Application No: LU/46/21/HH
Site Address: 38 Lyminster Road Wick Littlehampton BN17 7LB
Description of works: Single storey side/rear extension with alterations to front elevation

Thank you for your internet representation made on 31st March 2021 which has been recorded as an objection with the comments as follows:

Plan View Design

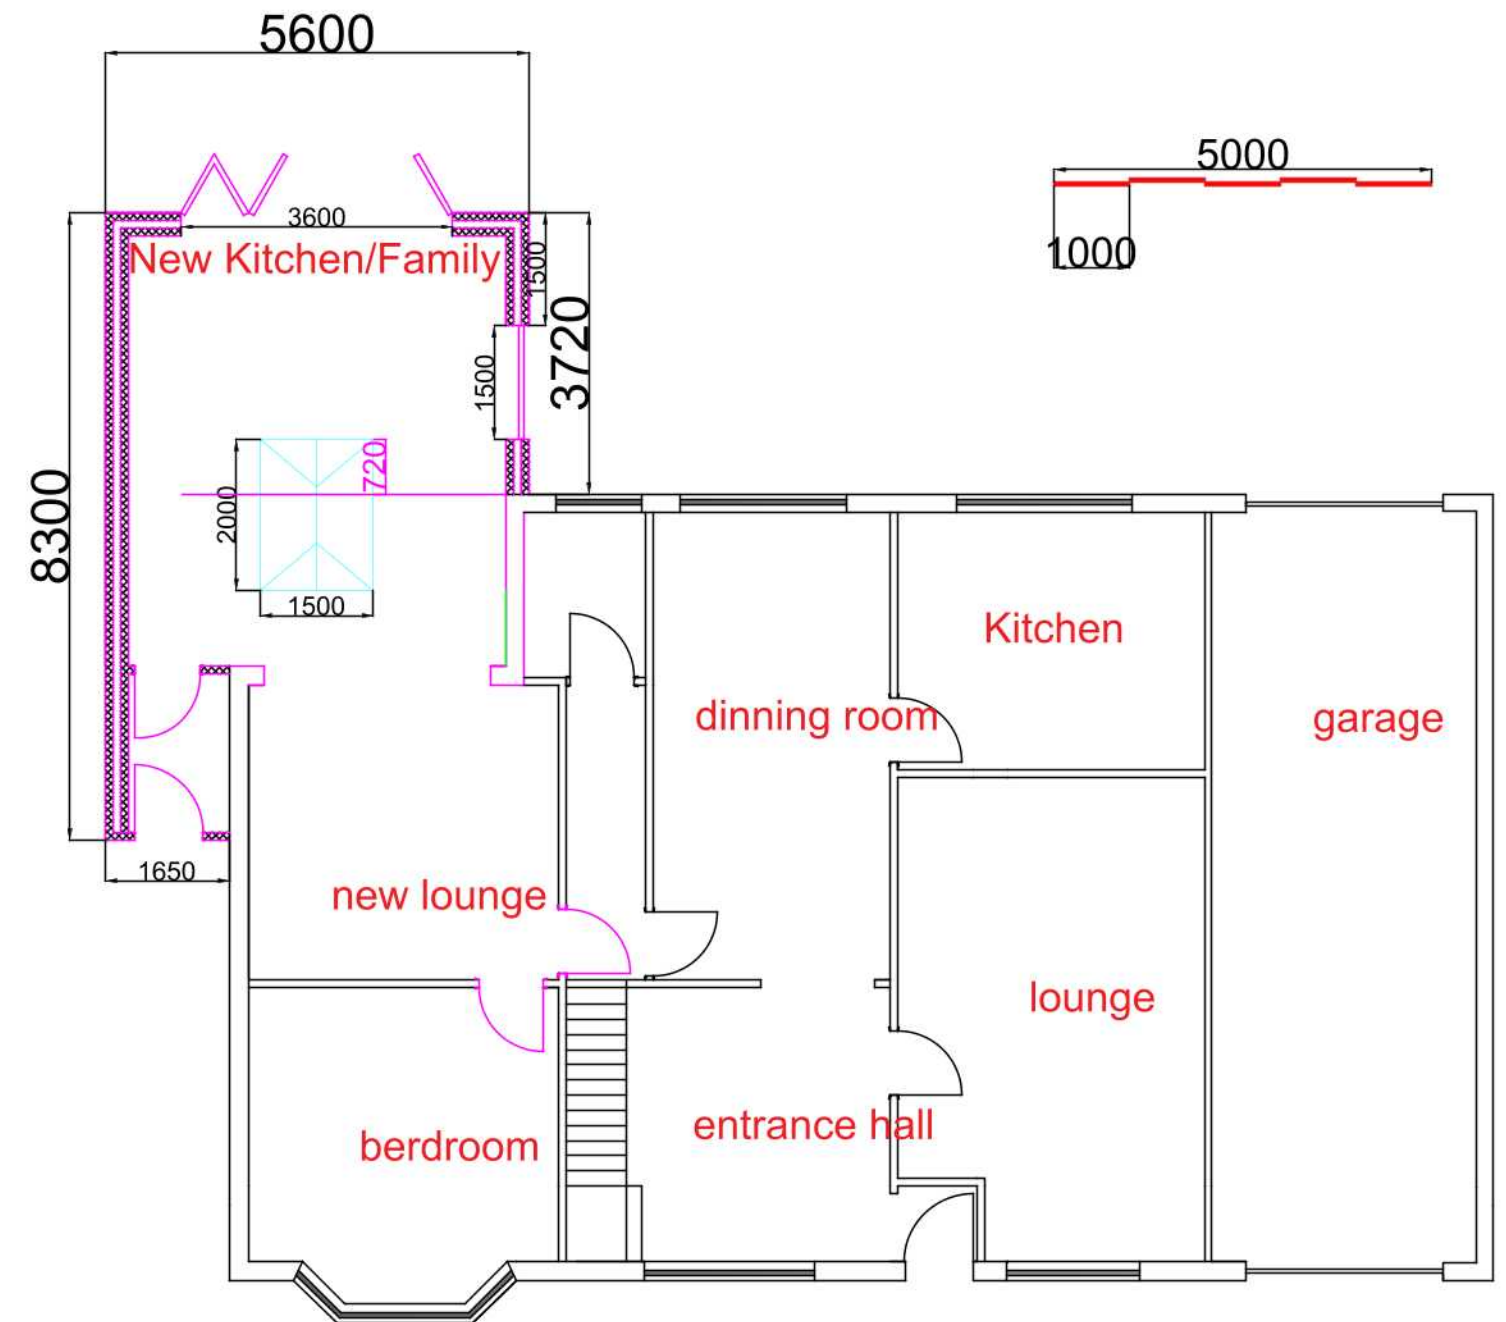
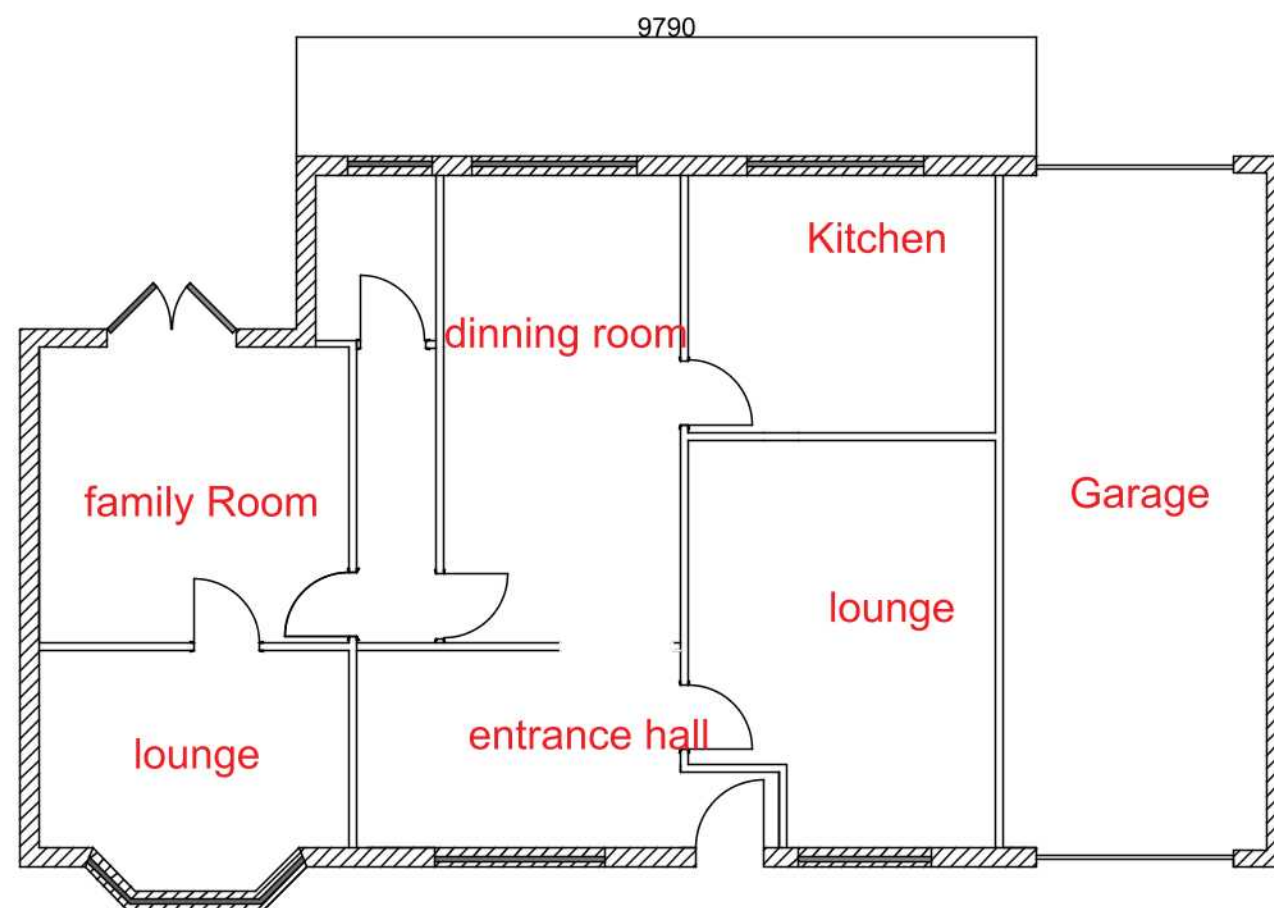
The Town Council's Planning and Transportation Committee considered this matter at its meeting held on Monday 29th March 2021 and objected to the application. The Committee were concerned that the design, being required to provide additional living accommodation, contained no provision for bathroom facilities.
